CITY OF ALBUQUERQUE

July 7, 2021

Re: Cottonwood Classical – Portable Addition
7801 Jefferson St NE
Traffic Circulation Layout
Architect's Stamp 05-19-2021 (D17-D003A)

TCL-001

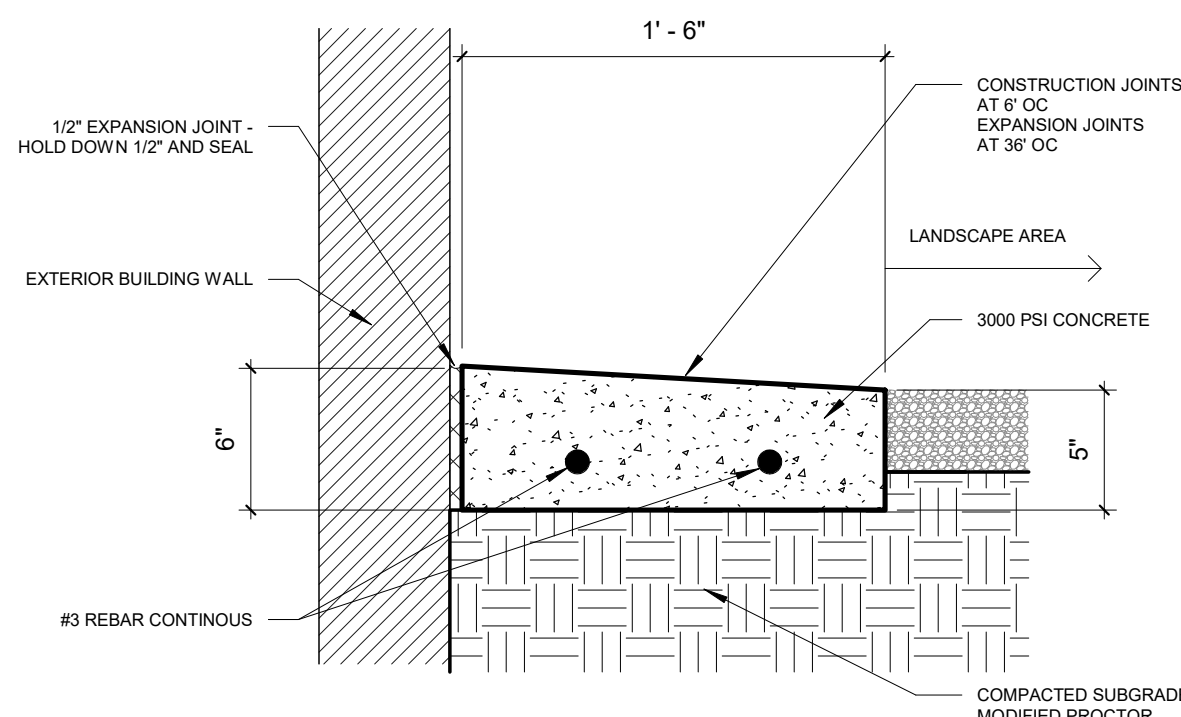
1. **Please show a vicinity map showing the location of the development in relation to streets and well known landmarks.**
2. **List the number of parking spaces required by the IDO as well as the proposed number of parking spaces including bicycle and motorcycle parking. Discuss with Zoning.**

3. **The proposed Modular Buildings;**
 - **Three buildings are blocking 7 stalls. Has the deletion of these stall been included in the over all parking calculations?**

- **Does these buildings need parking stalls? Especially ADA parking to service these buildings? Since the existing parking lot has no striping to delineate individual stalls.**

- **Provide dimensions for drive aisle leading into existing parking lot.**
4. **Activity area adjacent to entrance drive aisle appears to be proposed or is it existing. Please label this area as either existing or proposed based the line type.**

6. **Label all street names on site plan.**
7. **Site Plan sheet : Sheet title calls out for Traffic Control Layout. This is incorrect. Please label the sheet as CIRCULATION and not Control. Traffic Control requires a different type of certification from the designer**
